From: Jacqui Narvaez-Jimenez [REDACTED]
Sent: 17 November 2018 15:19
To: Zac Denton
Subject: LU/235/18/PL

From: Christian Melgar [REDACTED]
Date: 19 July 2018 at 16:23:45 BST
To: 'Jacqui Narvaez-Jimenez' [REDACTED]
Subject: RE: 36 Pier Road, Littlehampton

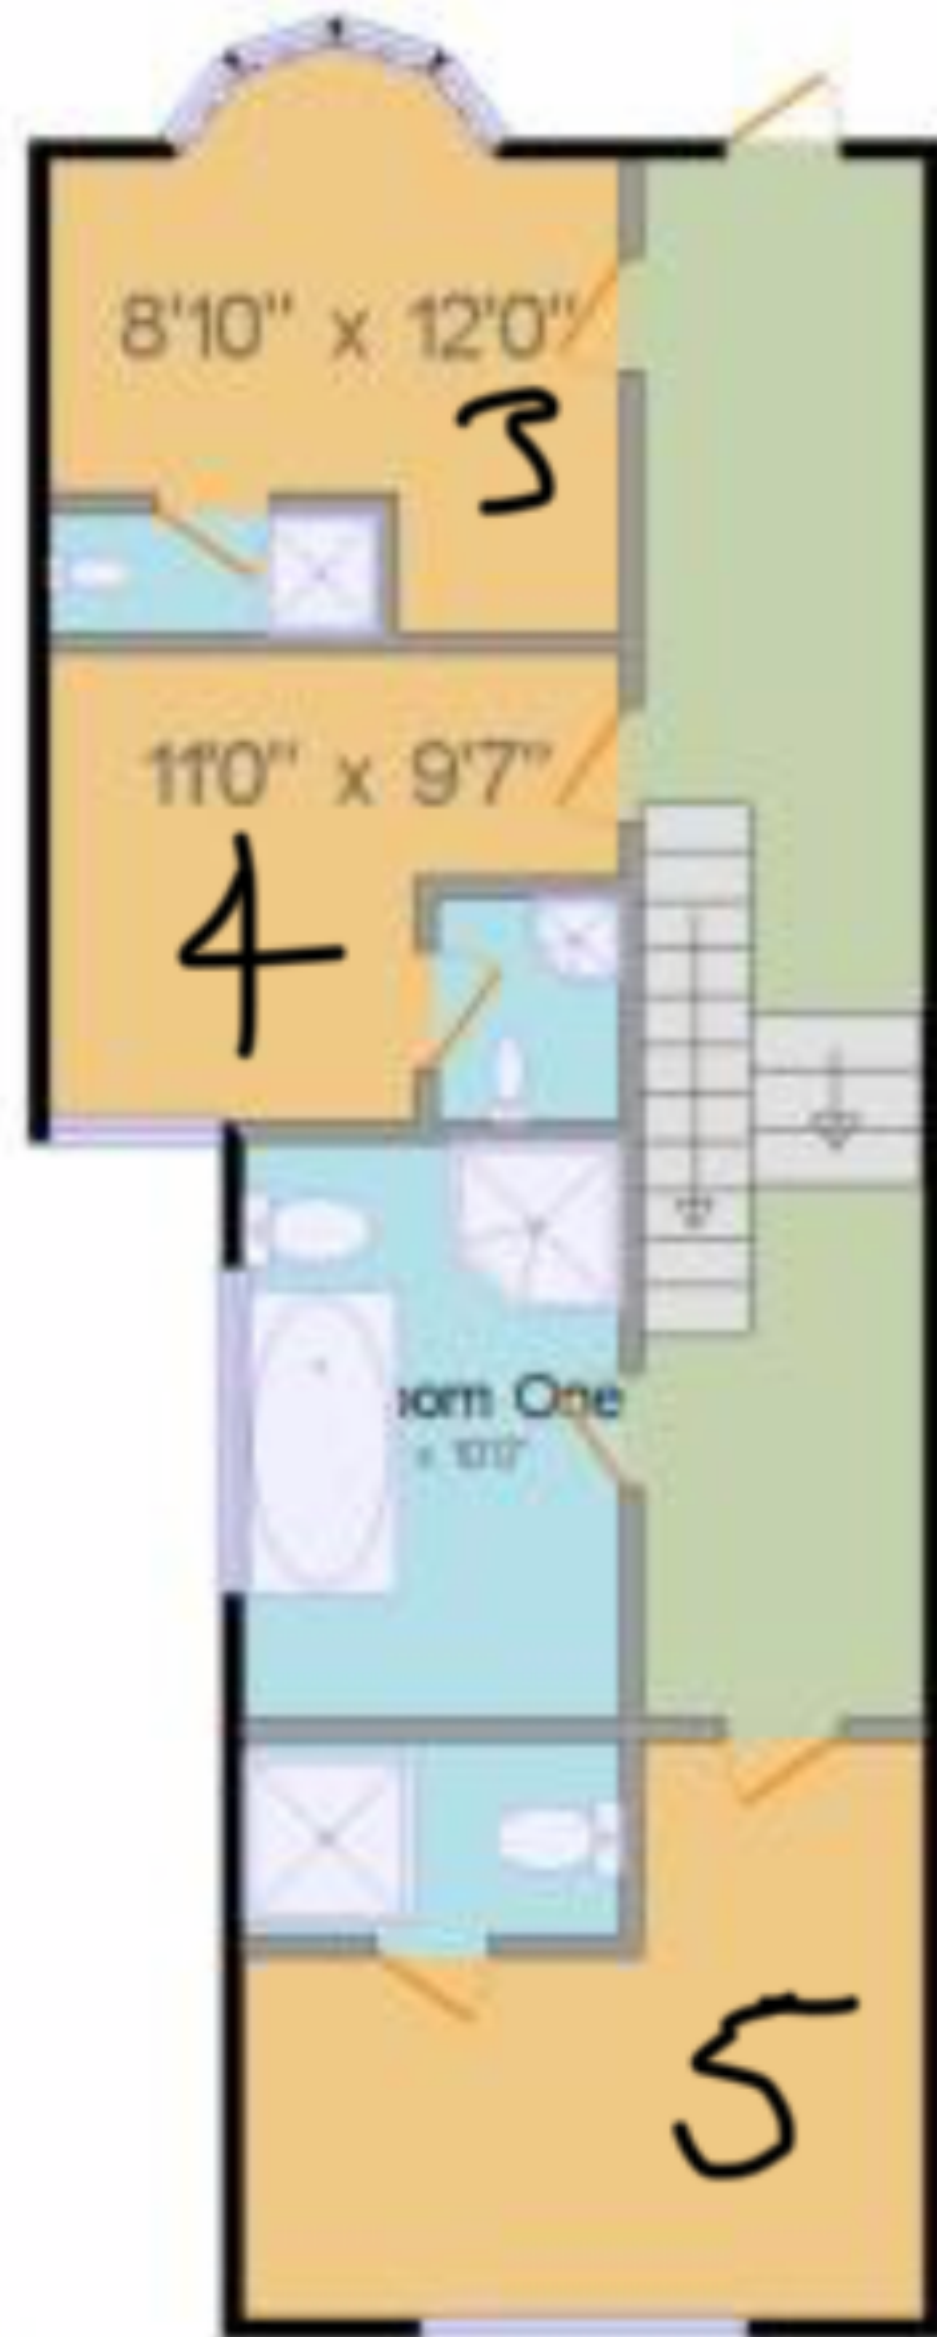
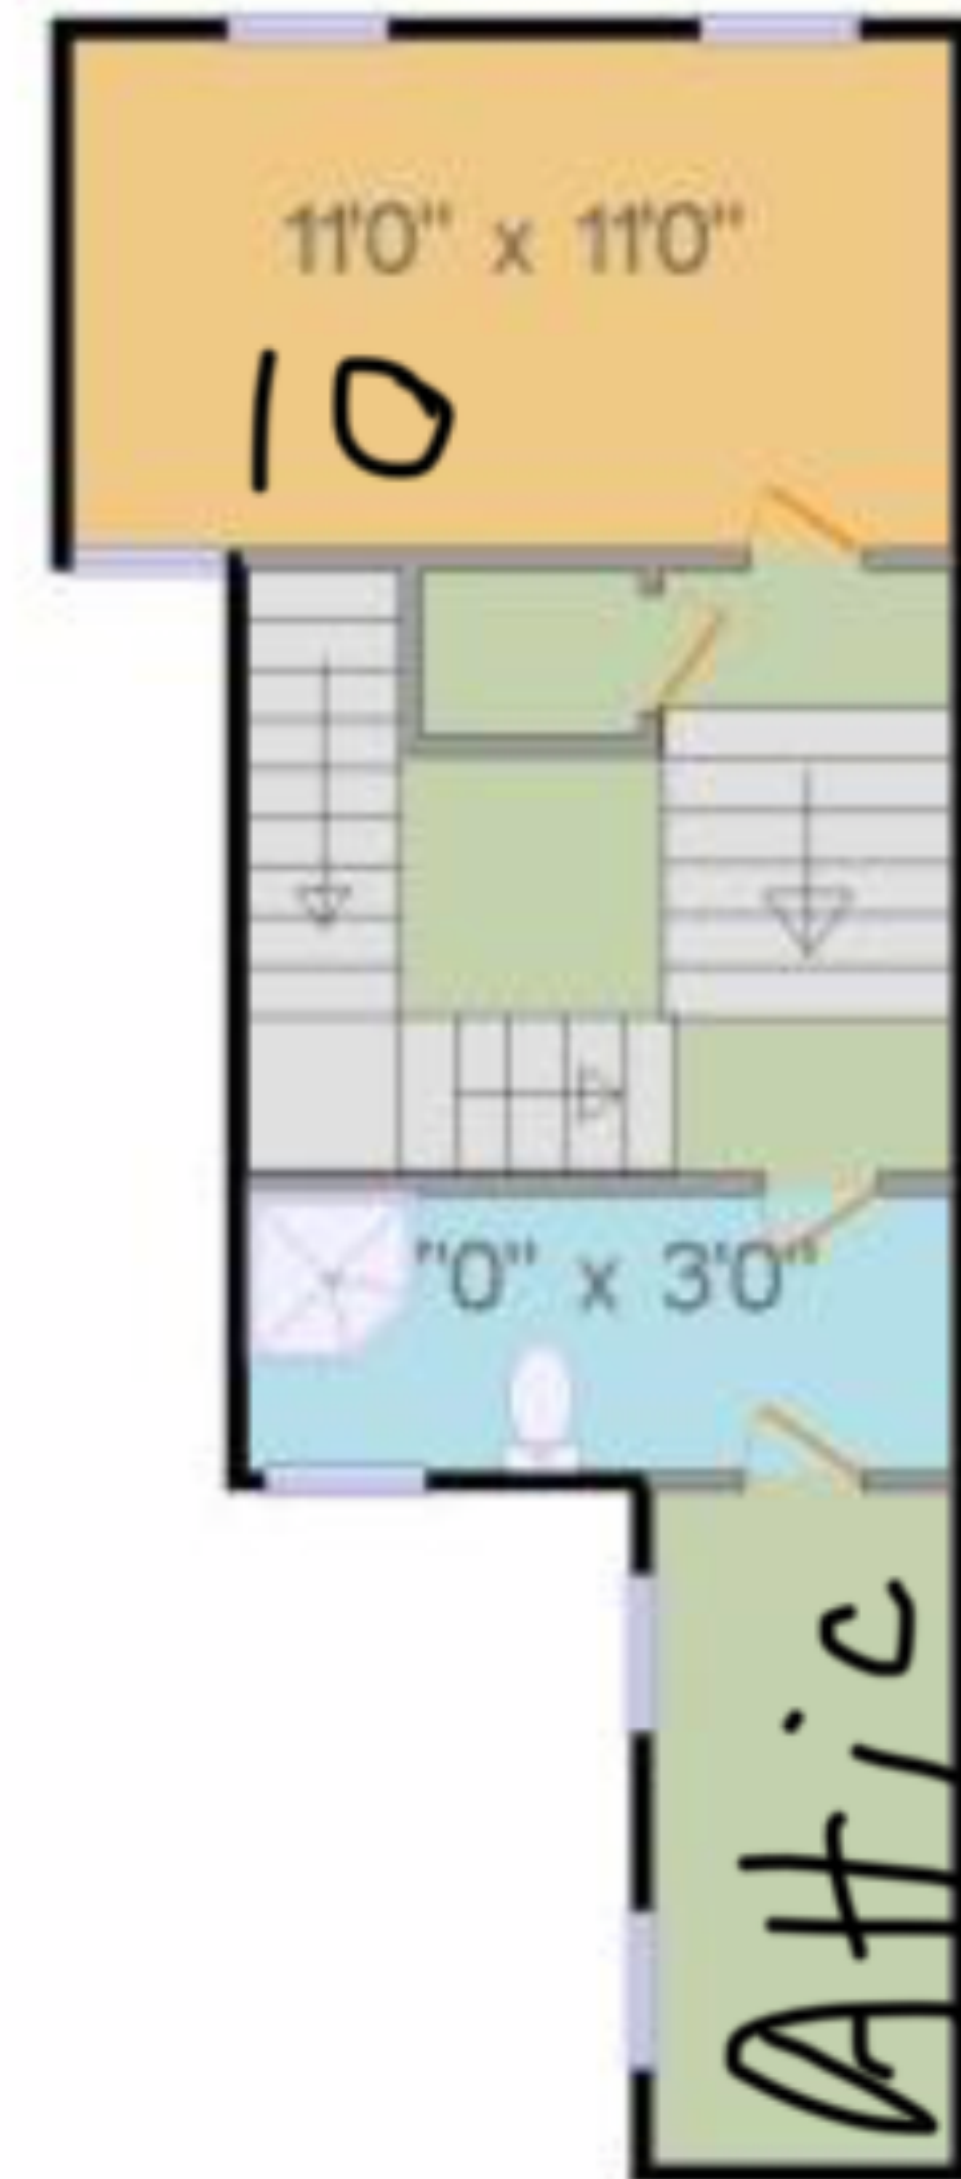
As long as there is sufficient seating and dining space for the number of occupants then it is likely that a couple of bar stools at the island unit would be countable, but I don't think it would be appropriate if this was the only seating/dining space available or the main provision for dining. If the island was removed I guess there may be enough room for a decent-sized table and sufficient chairs, but you would lose out on storage space and worktop area.

Rooms 1, 3, 6, and 10 could potentially be used as doubles for married/co-habiting couples but the dining area size would limit them to one occupant each, so unless you can provide additional suitable dining space (additional tables and chairs not just bar stools) you would be limited to singles.

Further to the latest comments on the application, please find below an email regarding the number of persons/room criteria explained to me by Mr Melgar. I have provided an extending table that can seat 12 people, plus I have two bar stools. Not that I wish to cram in too many people, but you will see that I have provided adequate facilities to accommodate the doubles if necessary, ie, 14, so perhaps you could bear that in mind if there are any queries?
